Response to Submissions

Supporting Documentation for a Request to Modify Project Approval PA 07_0155 (Ardmore Park Quarry)

August 2010

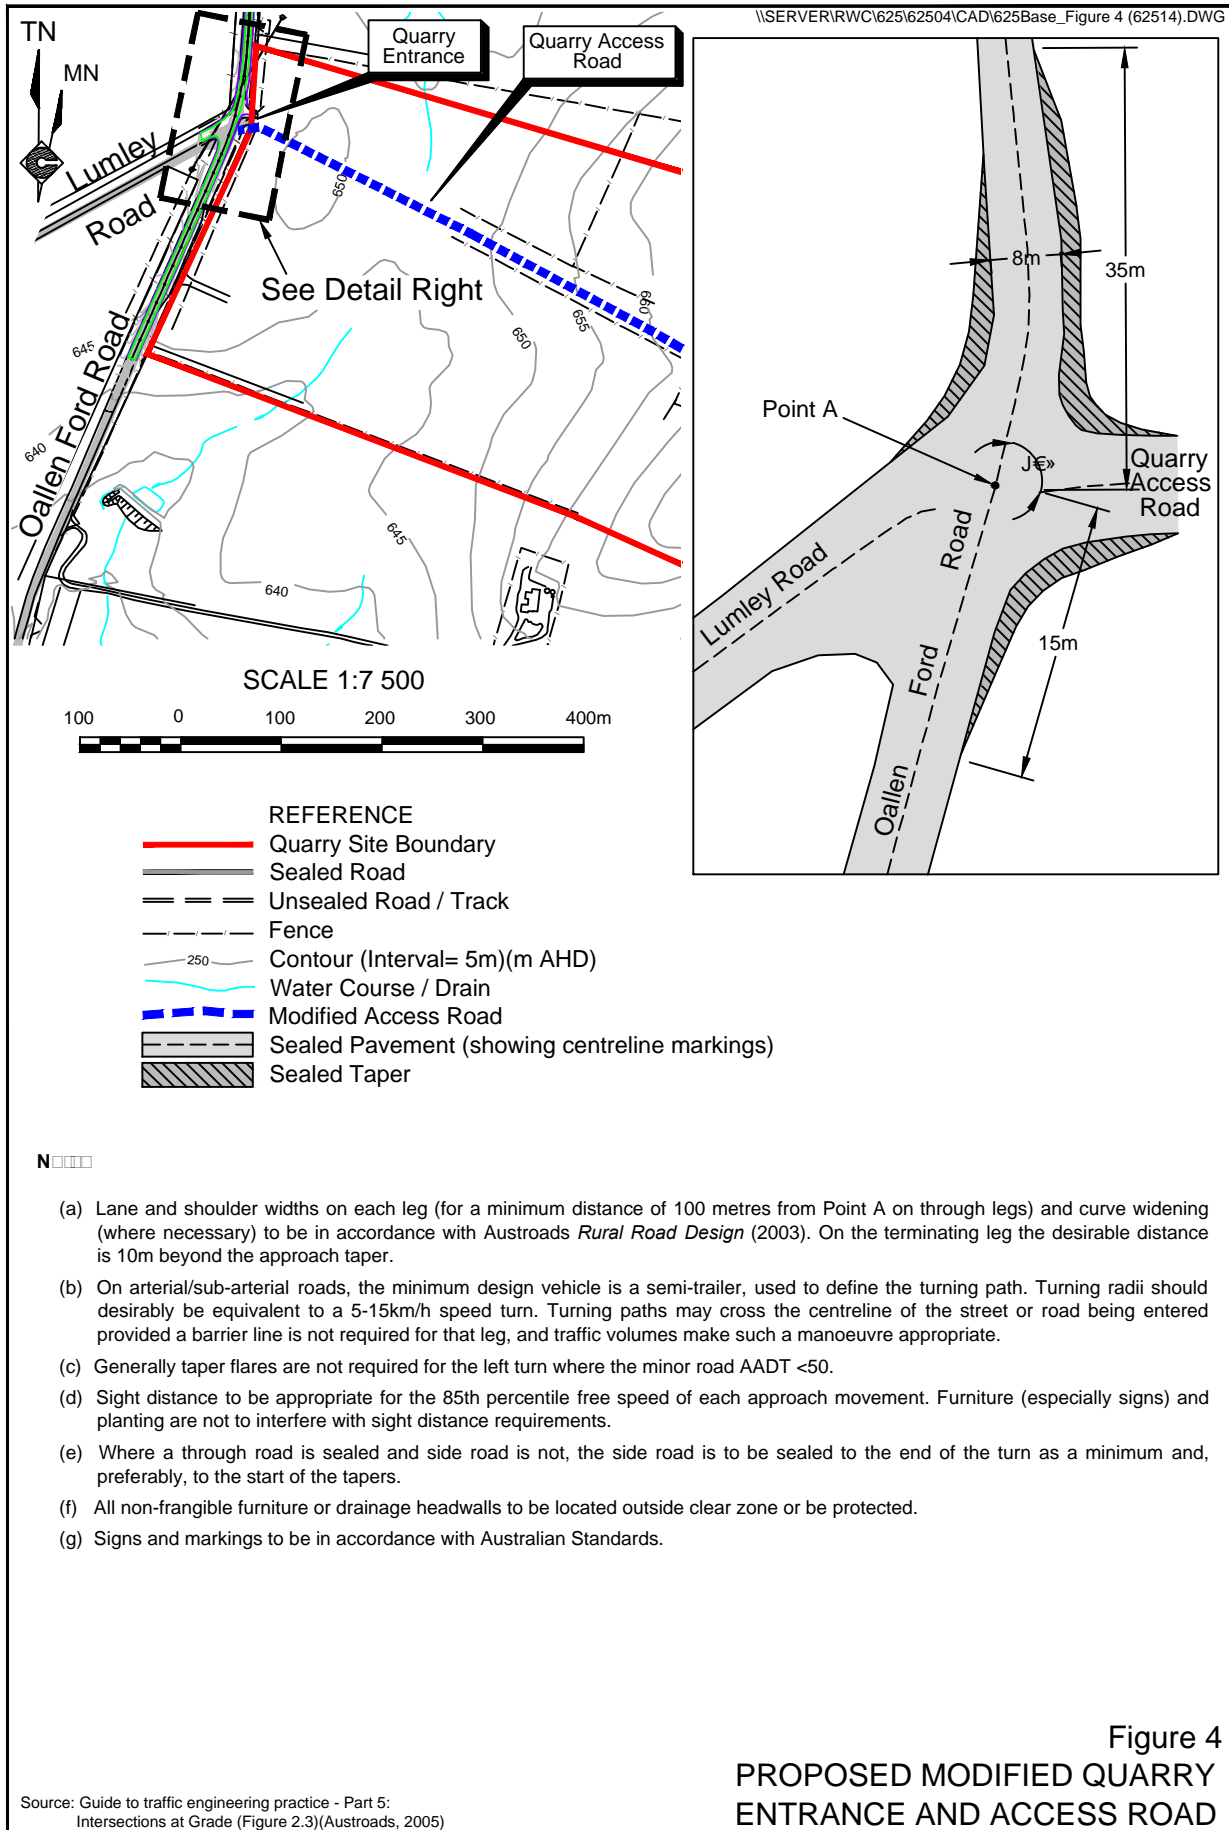
The proposed new entrance to the quarry site is even more unsafe than the previous entrance approved by your department. Further to this issue, the diagrams in environmental assessment (07_0155 Mod 1) showing the proposed quarry entrance are totally inadequate and do not indicate clearly exactly where the proposed entrance begins in relation to adjoining properties.

Contrary to the claim of D. Cole, the property boundary between the "Ardmore Park" property and that of D. Cole is provided on both **Figure 4** (represented by the fence line) and **Figure 5** of RWC (2010).

Further, it appears that having the two intersections opposite each other could well lead to unforeseen dangers, such as B-double trucks crossing the centre line of the road in order to make the turn into the quarry premises. Should this happen, an accident could well occur.

In response to the concern raised in relation to the B-double trucks crossing the centre line of the road in order to make the turn into the quarry premises, the intersection has been designed to meet RTA standard for a basic rural layout. This layout provides for the construction of a sealed taper for incoming trucks (see **Figure 4 of RWC, 2010**) which would ensure that the left-hand turn can be completed without the need for the truck to pull onto the right-hand side of the road.

As noted previously, the intersection has been designed to meet RTA standard for a basic rural layout. This layout provides for the construction of a sealed taper for incoming trucks (see **Figure 4** of RWC, 2010) which would ensure that all vehicle movements in and out of the quarry site can be completed without compromising the safety of other road users.
